Application Ref: H19-0329-24

Proposal: **Temporary ground mounted solar photovoltaic (PV) farm with battery storage, substation and associated works**

Location: **Land east of Guanockgate Road, Sutton St Edmund, Spalding, PE13 4PL**

Notice is hereby given that the County Council as Local Highway and Lead Local Flood Authority:

Figure 6f: Proposed Access track Construction

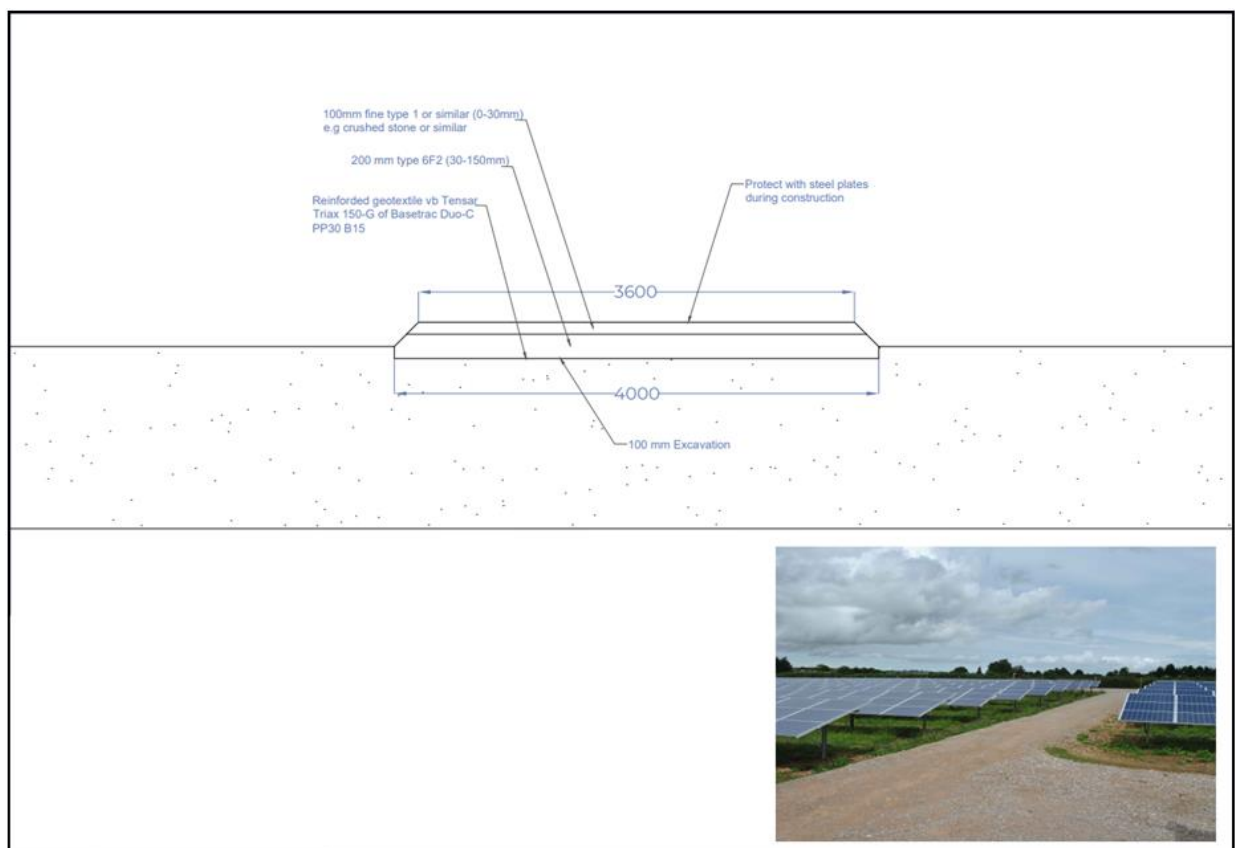
- ☐ The access track elevation indicates Type 1 will be used as surfacing material and steel plates will be placed over the Type 1 during construction of the solar arrays. Will the public footpath be open during the construction phase? Will the steel plates incorporate an anti-slip feature?
- ☐ Both public footpaths will require closing to enable the construction of the track.

Off-site Junction Location Plan

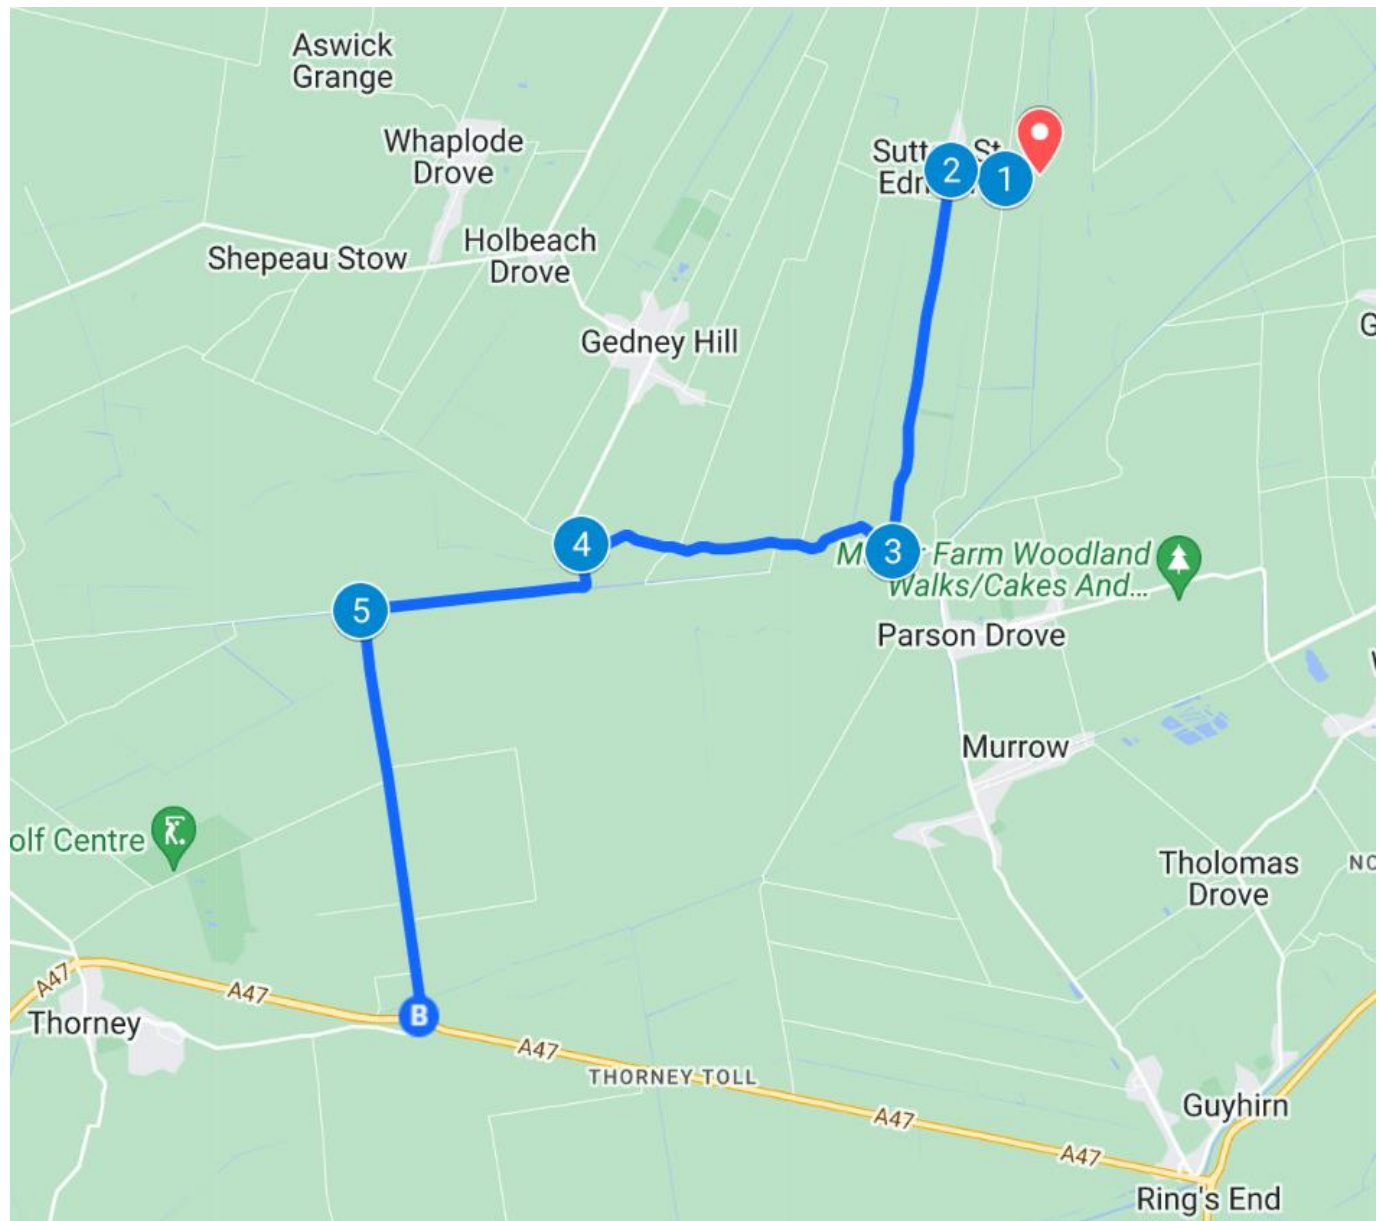
A swept path analysis for the turning movements of HGV's are to be provided in both directions for the following junction assessments: -

The B1161 with French Drove

The B1166/Old South Eau Drove with the B1167/French Drove

The B1166/Old South Eau Drove with Broadgate

Broadgate with Cross Road

Regarding the swept path analysis at the B1166/Old South Eau Drove with Broadgate junction, the Highway Authority are of concern with the vehicle movements from Broadgate turning right on to the B1166/Old South Eau Drove due to restricted visibility splayed from the overgrown hedge. Therefore, to mitigate our concerns, we would ask the application how they intend to provide safe and suitable visibility for those movements.
